**CITY OF ALBUQUERQUE
PLANNING DEPARTMENT
January 30, 2008
DRB Comments**

RE: Lot 1-A, Motorola Replat

DEVELOPMENT REVIEW BOARD--SPEED MEMO

**RE: REQUEST FOR SKETCH PLAT REVIEW, LOT 1-A, MOTOROLA REPLAT
LOCATED ON ALAMEDA BLVD. N. E. BETWEEN WASHINGTON STREET N.
E. AND JEFFERSON STREET N. E. ZONE ATLAS PAGE C-17**

Sketch Plat of  
Lots 1-A-4 through 1-A-3

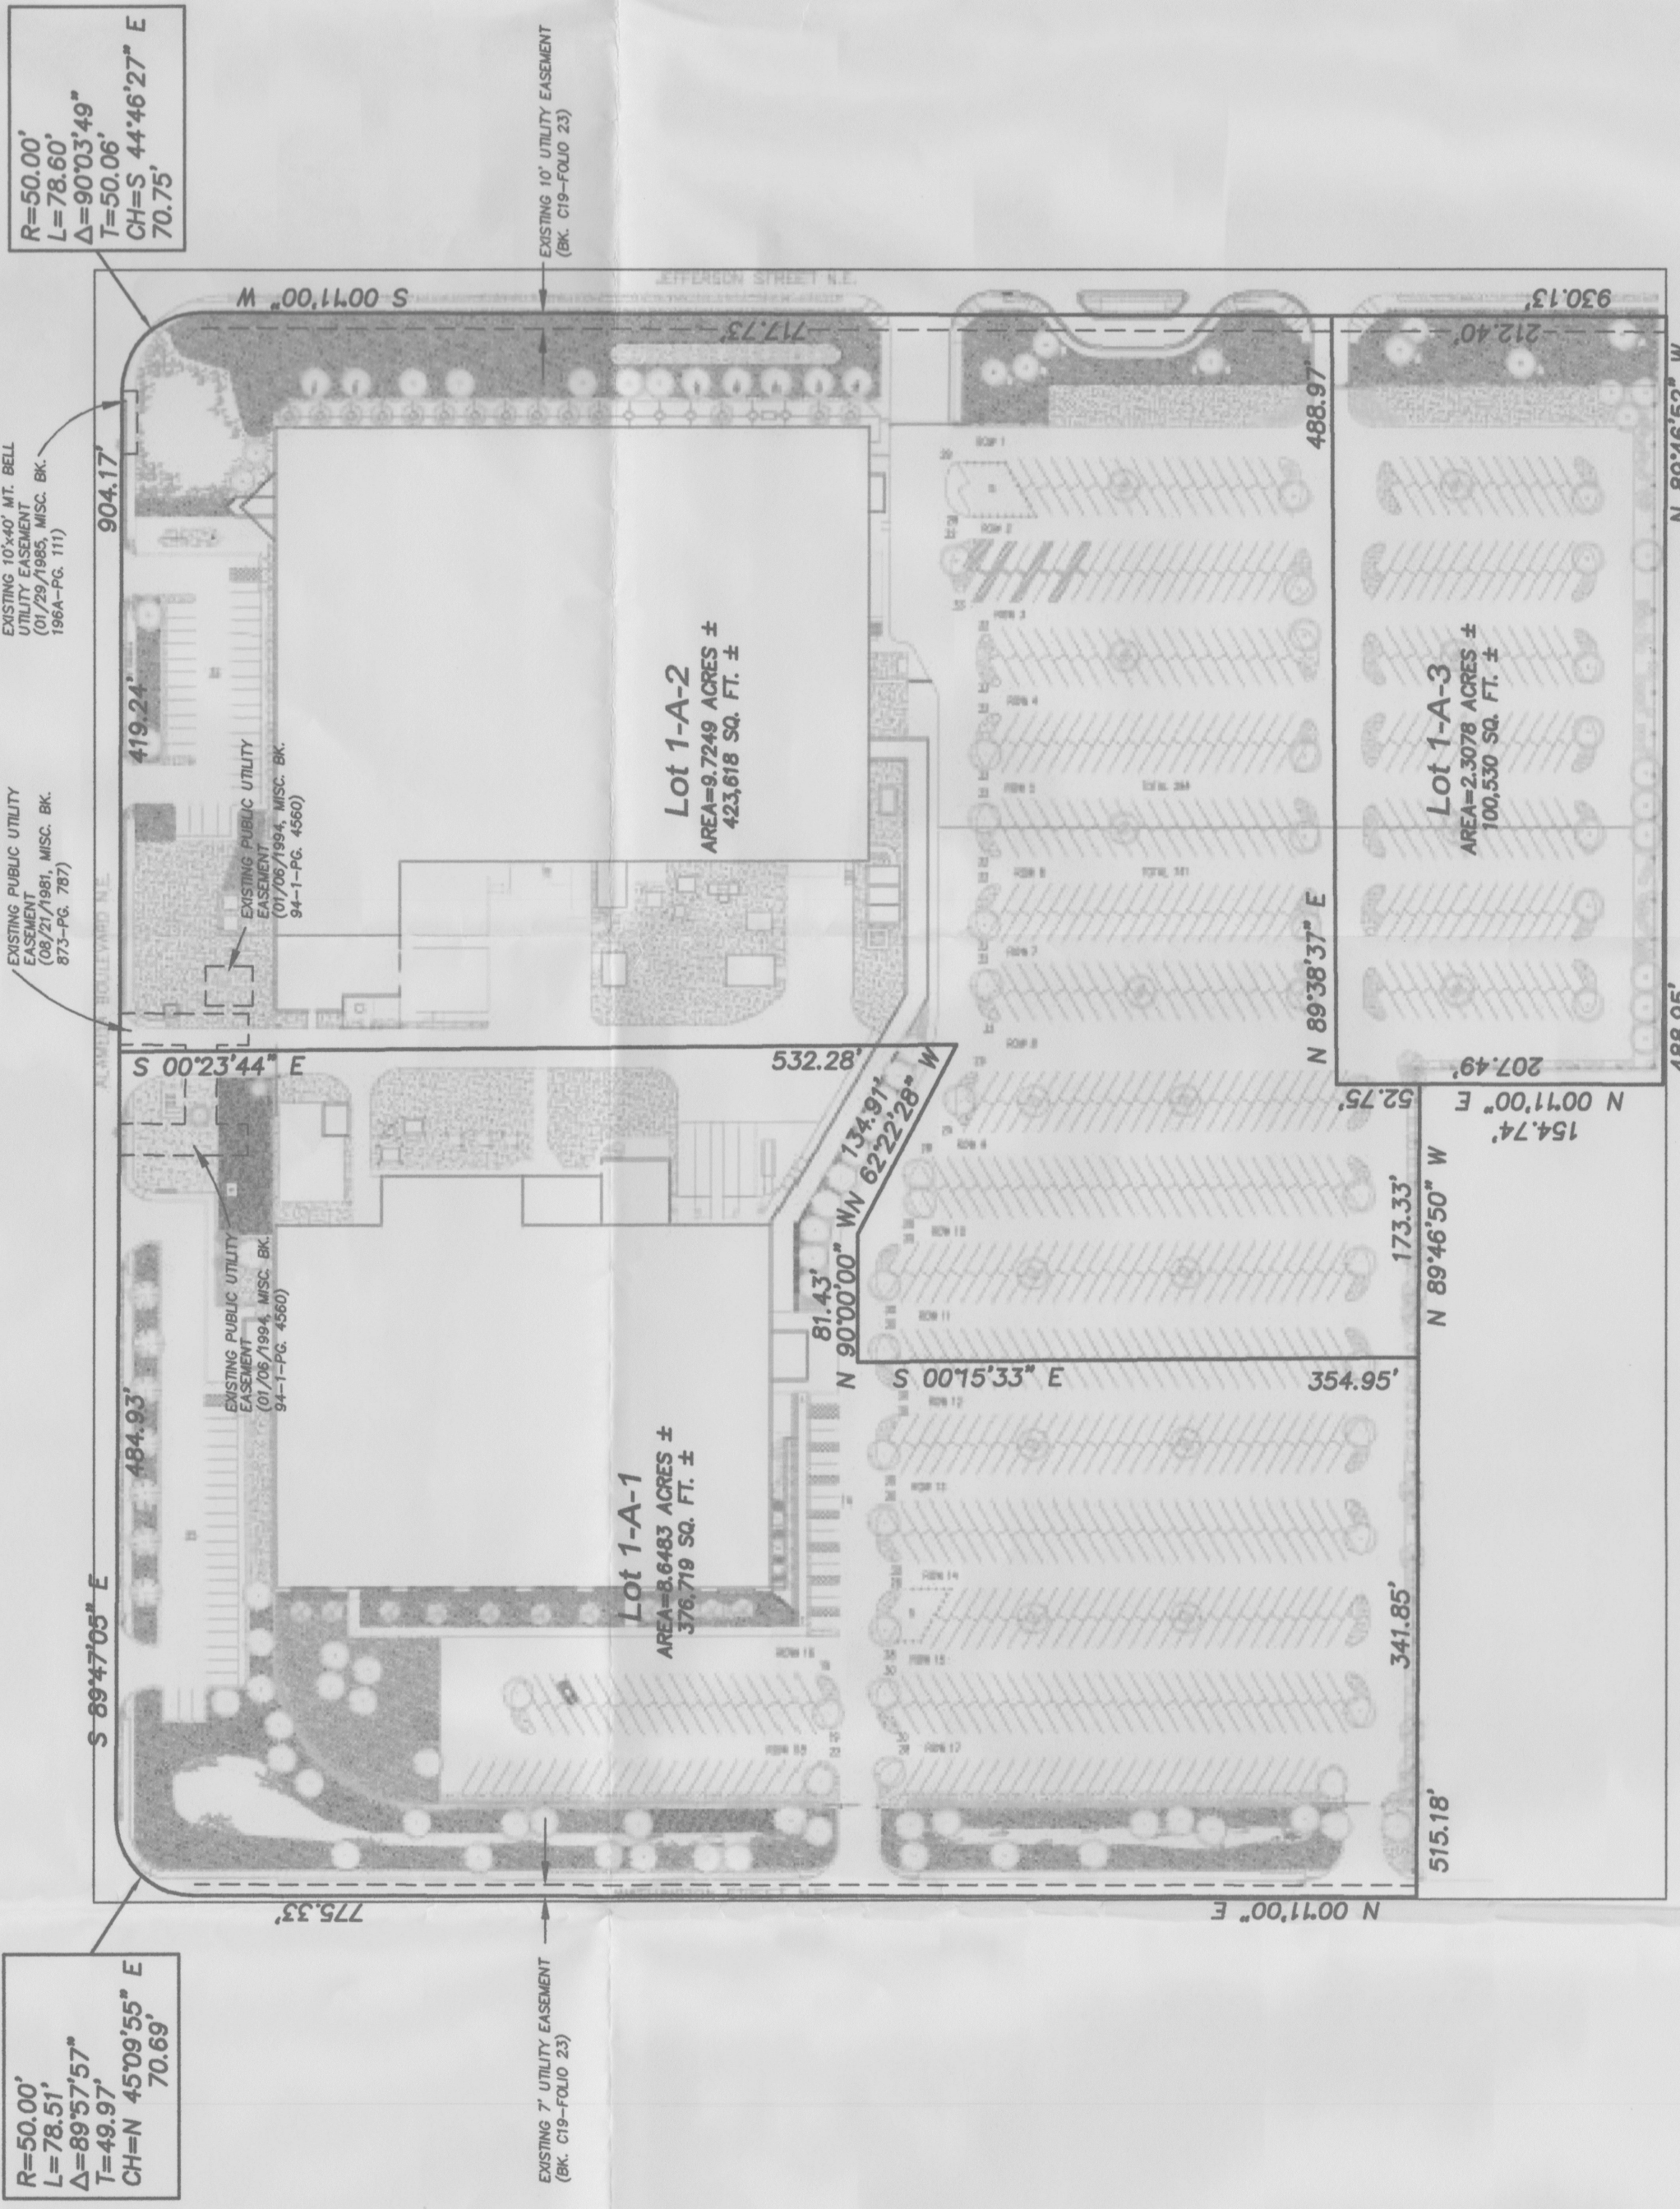
For future reference, please revise solar note to be specific to this type of request, i.e. replace the words "REQUESTED FINAL ACTION" with the words "THIS PLAT" at the beginning of the note, and delete the words "OR SITE DEVELOPMENT PLAN FOR SUBDIVISION" at the end of the note.

Plat of  
**Lots 1-A-4 through 1-A-3**  
**Motorola**  
 Albuquerque, Bernalillo County, New Mexico  
 January 2008

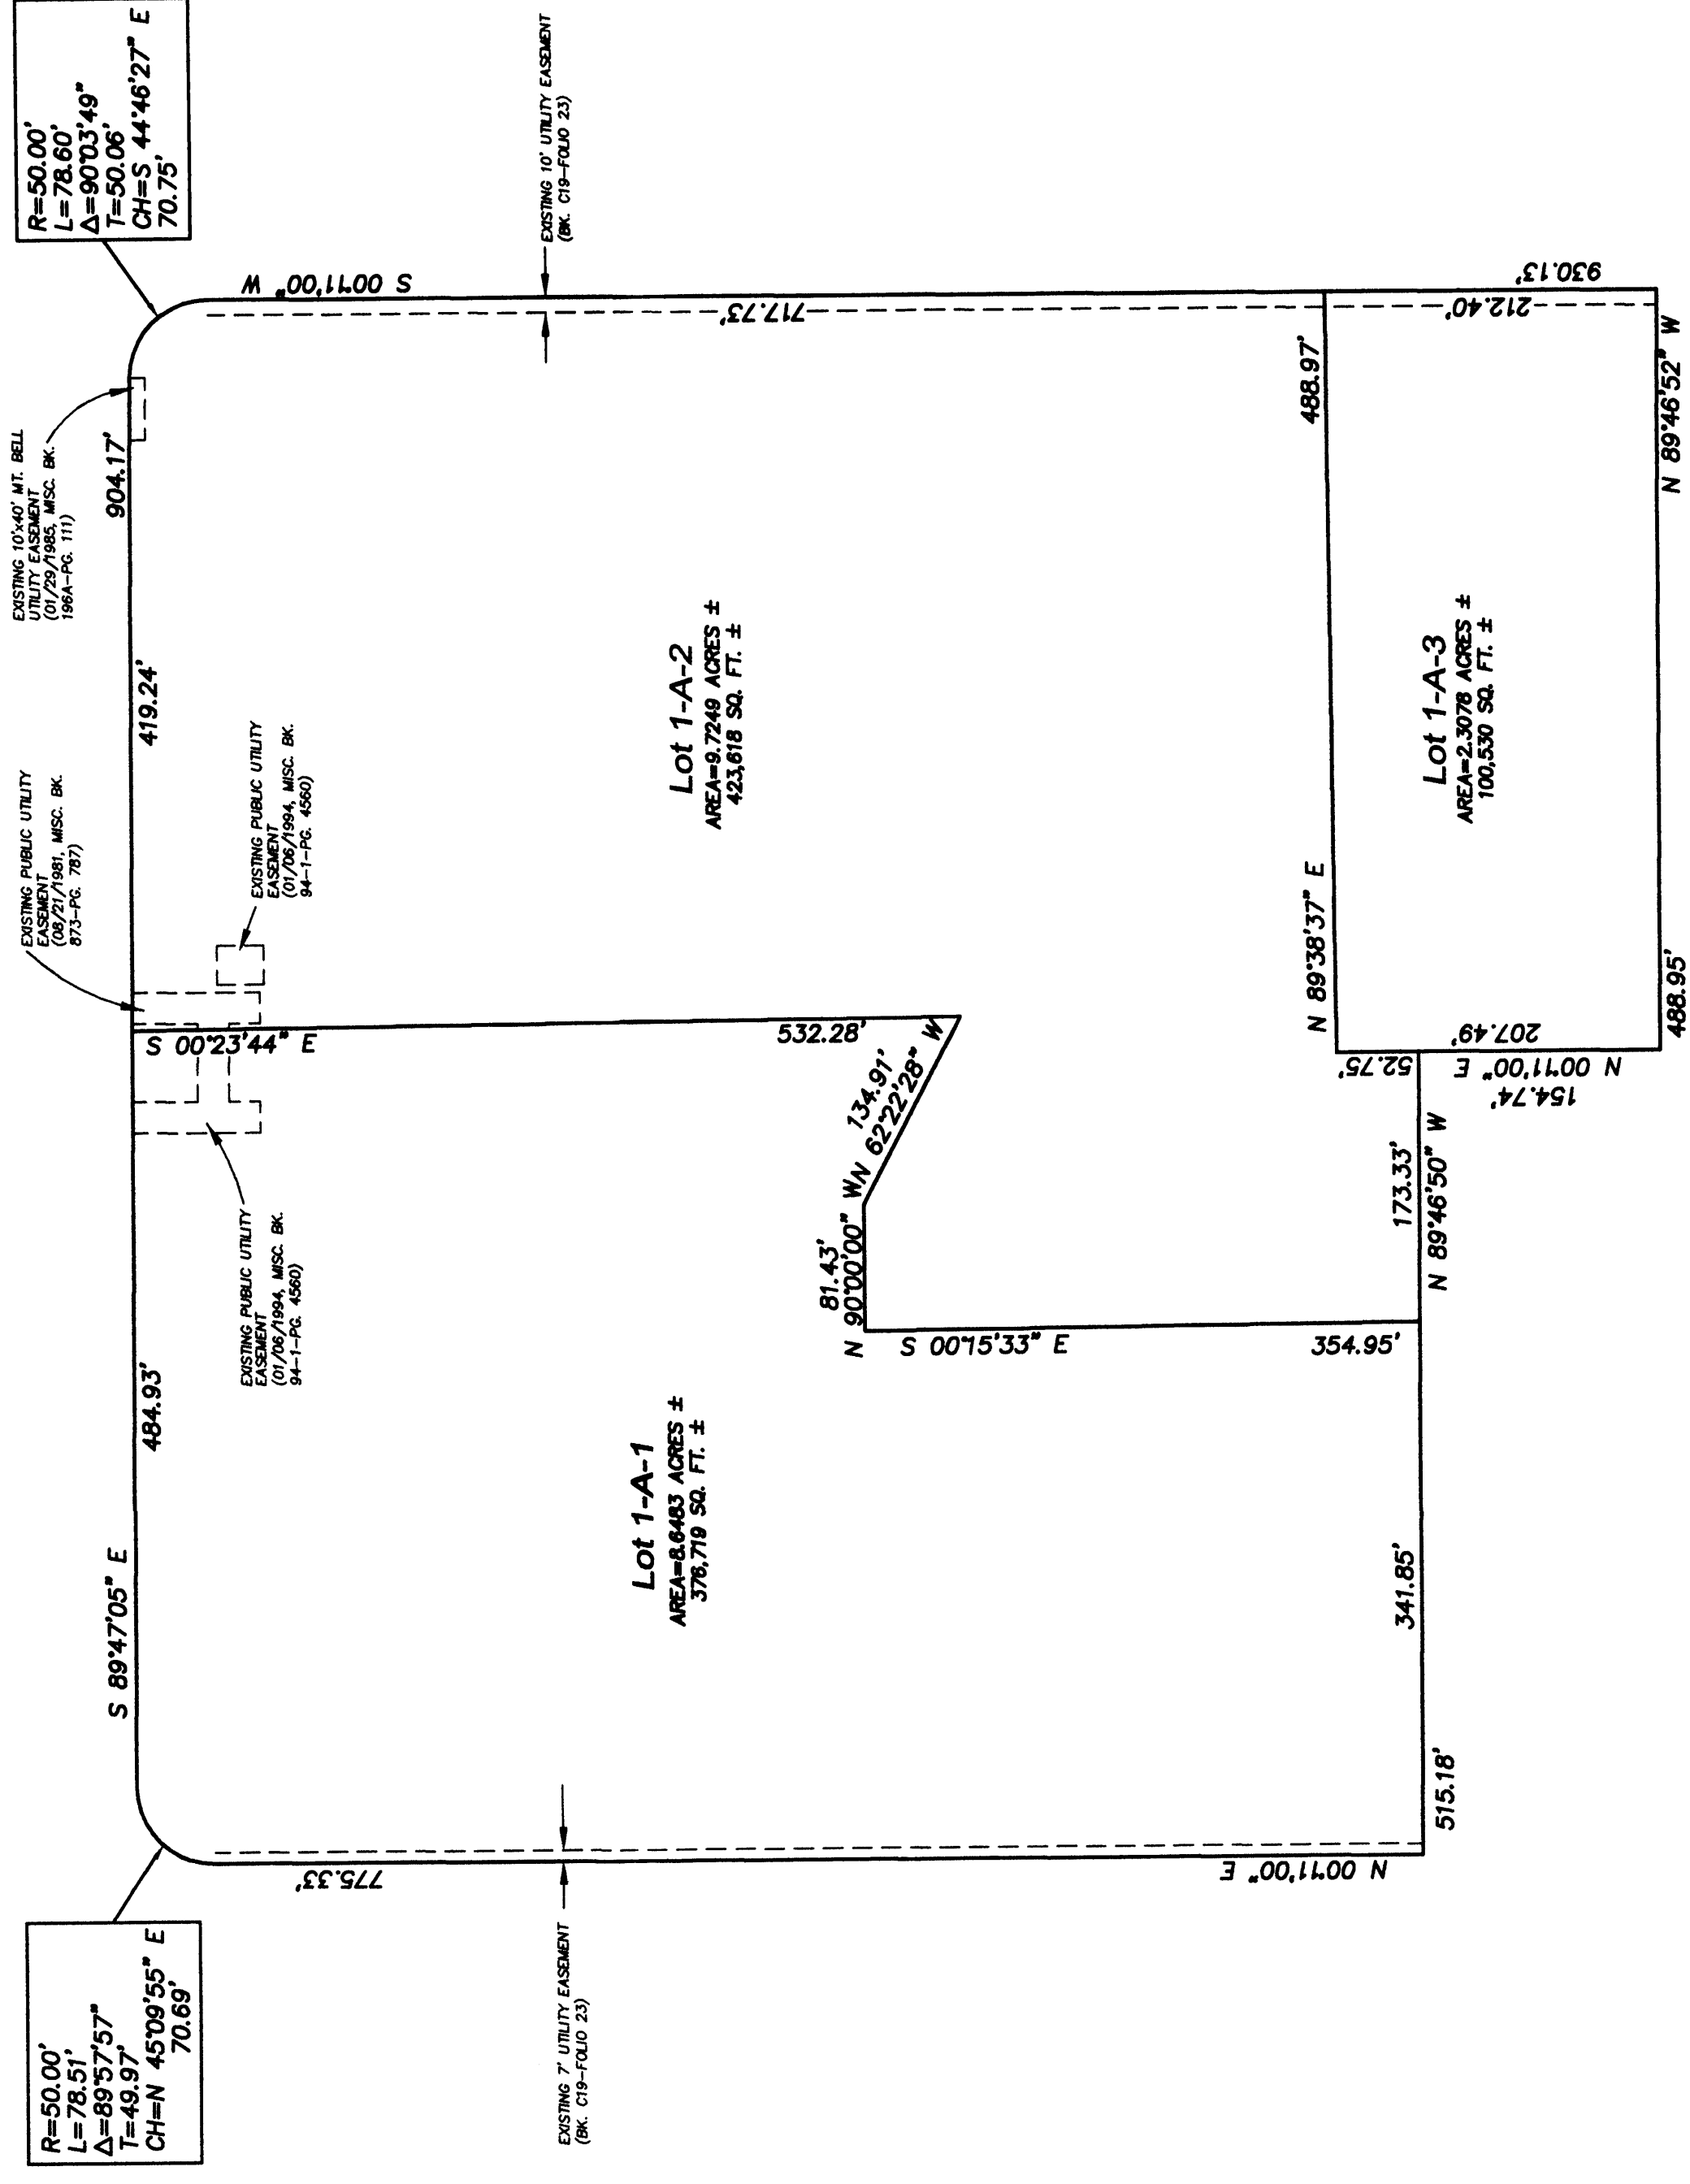
Certification will be needed that the existing building conforms to the City's Zoning Code regarding on-site parking for the proposed lot(s).

Cross-lot drainage easement will be needed.
